Project: 593 Washington Avenue, Portland Me.

Engineering Design Computations: Calderwood Engineering

Note the building is fully constructed and the attic apartment is currently vacant and awaiting an engineering analysis of the existing building framing in order to verify that it is safe to use as a finished building space.

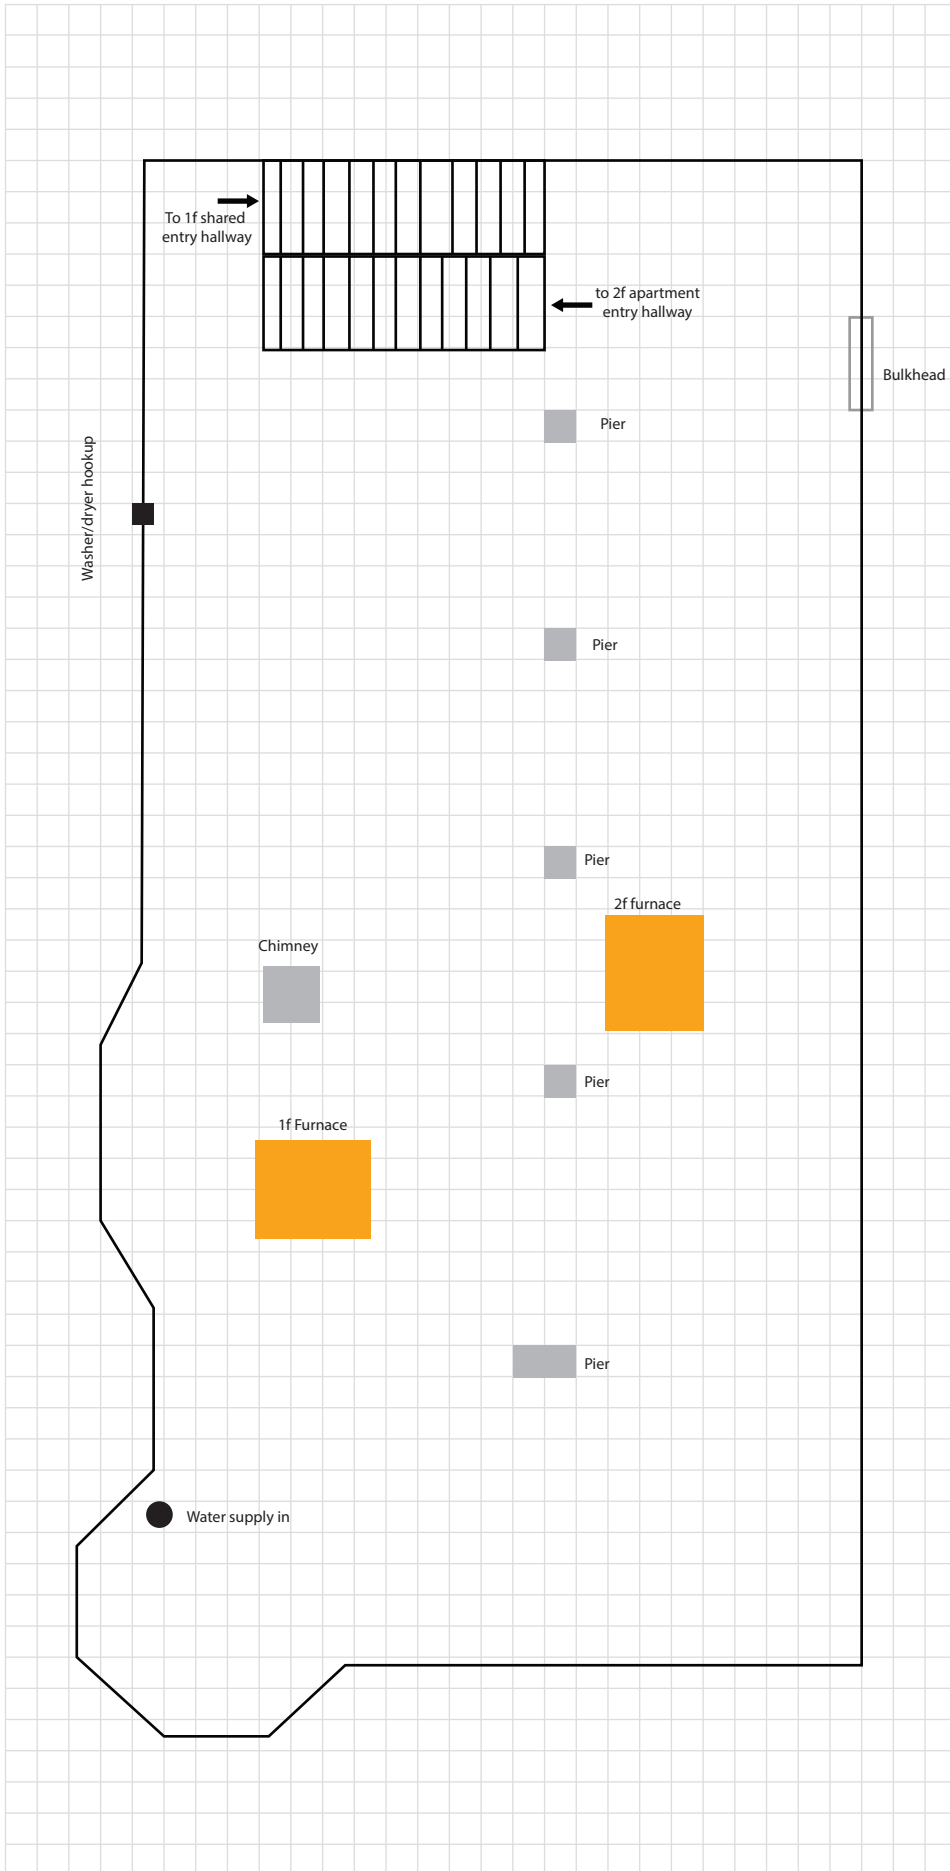
Basement Girder:

2192 psi >> 1050 psi therefor strengthening req'd add'l posting req'd

install lally column to reduce maximum span from 10 ft to 6.5 ft in basement
